169 Newbury St., HVAC permit #2017-00010 plan review comments

1. Building/wall sections showing duct locations in relation to the fire rated assemblies.
2. Details on damper requirements at ducts and diffusers per IBC Sec. 716.

PROJECT:		LUMINATO NEWBURY STREET PORTLAND, MAINE
SHEET TITLE:		1ST & BASEMENT FLOOR DUCTWORK PLANS
SCALE: 1/8"=1'-0"	DATE: 11-22-2016	
DRAWN BY: A2Z CADD DRAFTING SERVICES, INC.	SHEET No.	M-1
CHECKED BY:		
XX

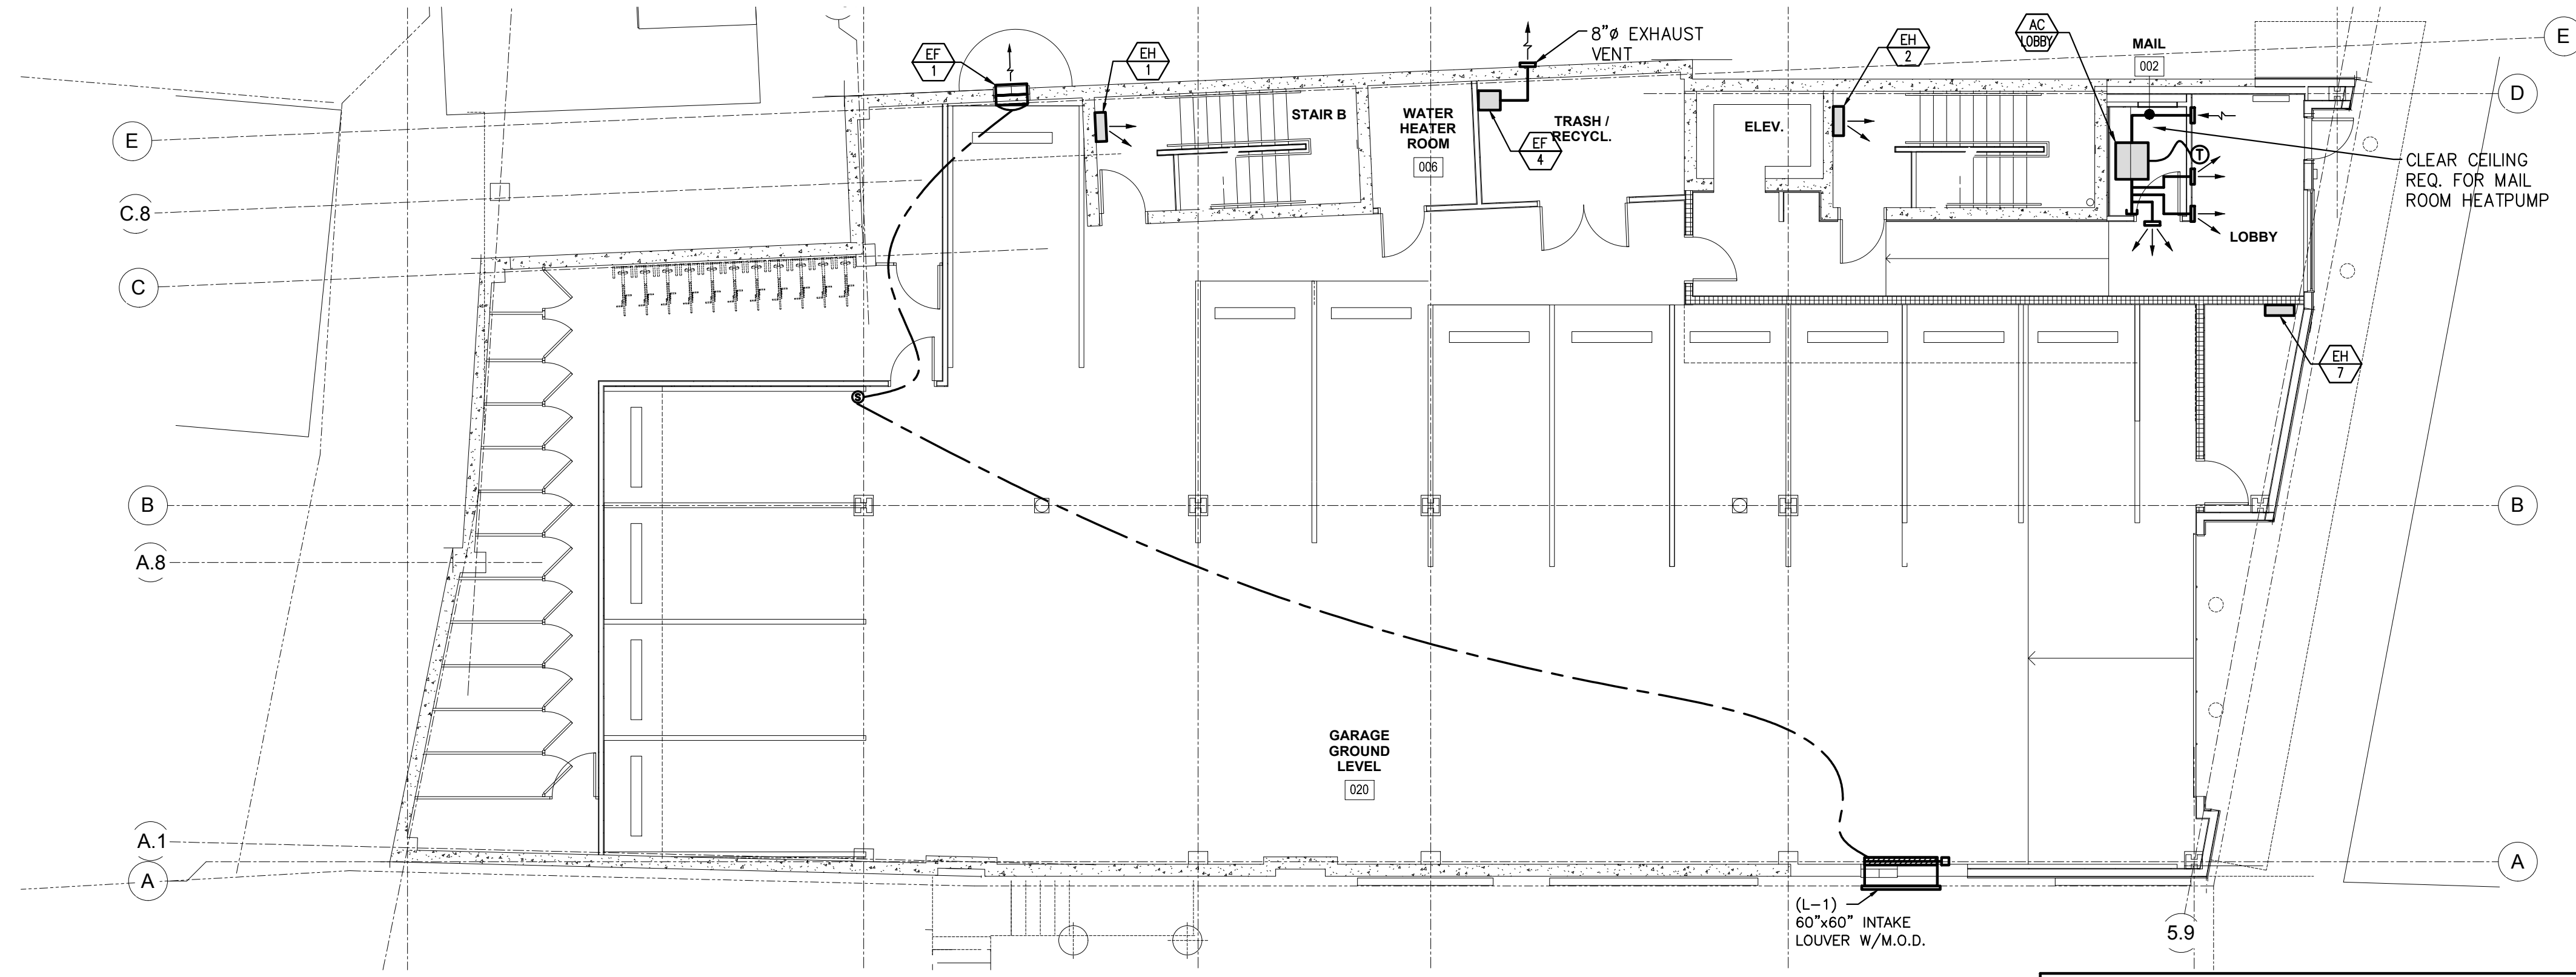
Thank you for this information, just to clarify (typo) the section you are referencing is 716.5.2. In addition, please confirm the same for smoke damper requirements per Sec. 716.5.4.1 and for ceiling radiation dampers in membrane penetrations per Sec. 716.6.2.

Can you please confirm your response to the ceiling radiation dampers? Are you saying they will be installed as tested per ASTM E 119?

If not, will they comply with exception 1 that requires tests in accordance with the same standards that show that dampers are not required?

All penetrations through 1 hour assemblies shall be solid ducting of a min of 26 gauge duct and do not require fire dampers per IBC sec 216.5.2 exception 3 with fully automatic sprinkled building. We have avoided any penetrations with any fire rated assemblies greater than 1 hour.

716.5.4.1 Corridors , again we will be installing solid duct not less than 26 gauge. 716.6.2.1 Ceiling radiation dampers ASTM E 119 with solid duct not less than 26 gauge. I will work on a M sheet for future applications. Please let me know if you need anything else.

If Conditions prevent us from ducting them with 26 gauge pipe we will need to install per ASTM E 119. Our intent is to hard duct all terminations for 1 hour rated assemblies. Our bath room exhaust fans will not meet the requirement, radiation dampers will be provided by manufacturer (Panasonic). I attached the spec sheet for the Panasonic radiation dampers.
